Project Special Provisions (Version 06.6) Signals and Intelligent Transportation Systems

1. 2006 STANDARD SPECIFICATIONS FOR ROADS & STRUCTURES

The 2006 Standard Specifications are revised as follows:

ENGLISH DETAIL DRAWING FOR
INDUCTIVE DETECTION LOOPS

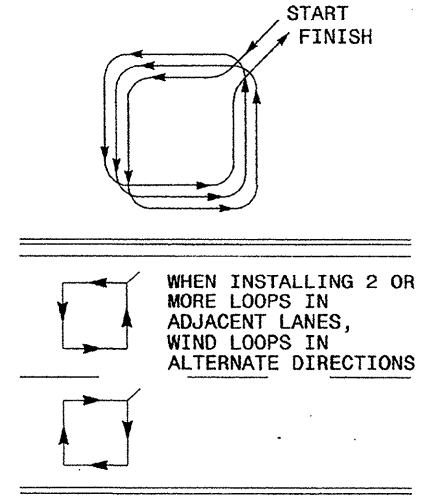
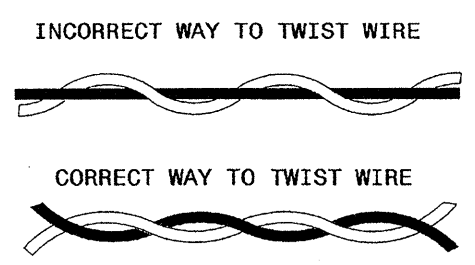
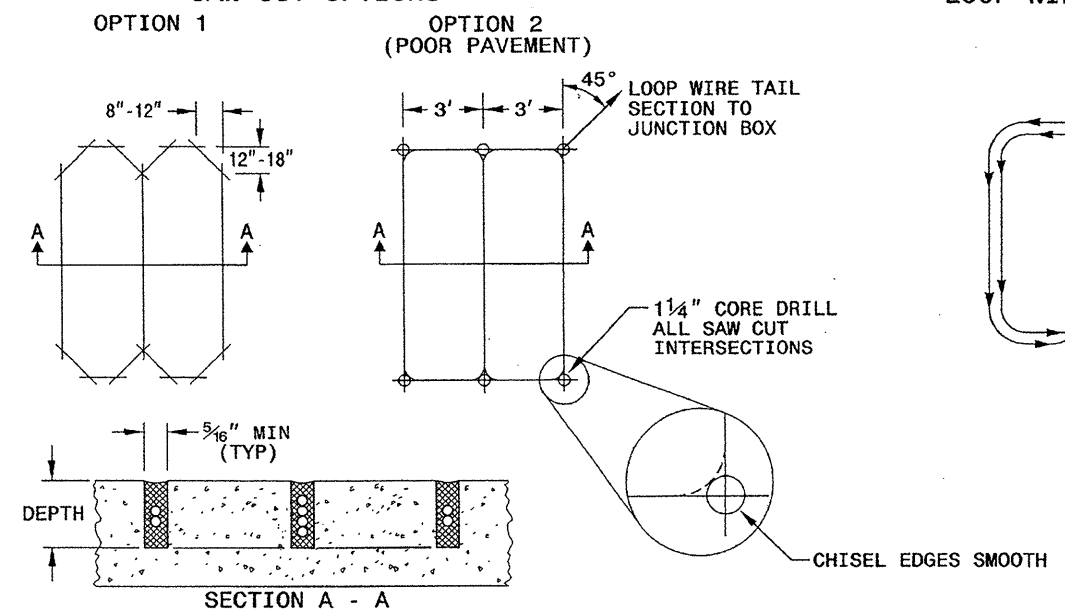
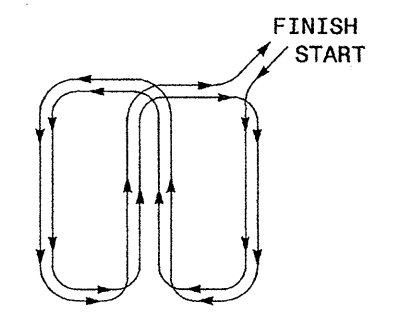
1.4. Inductive Detection Loops – Construction Methods (1725-3)

Page 17-20, Subarticle 1725-3, In the first paragraph, revise the first sentence to:

“Between where loop conductor pairs leave saw cut in pavement and junction boxes, twist loop conductor pairs a minimum of 5 turns per foot.”
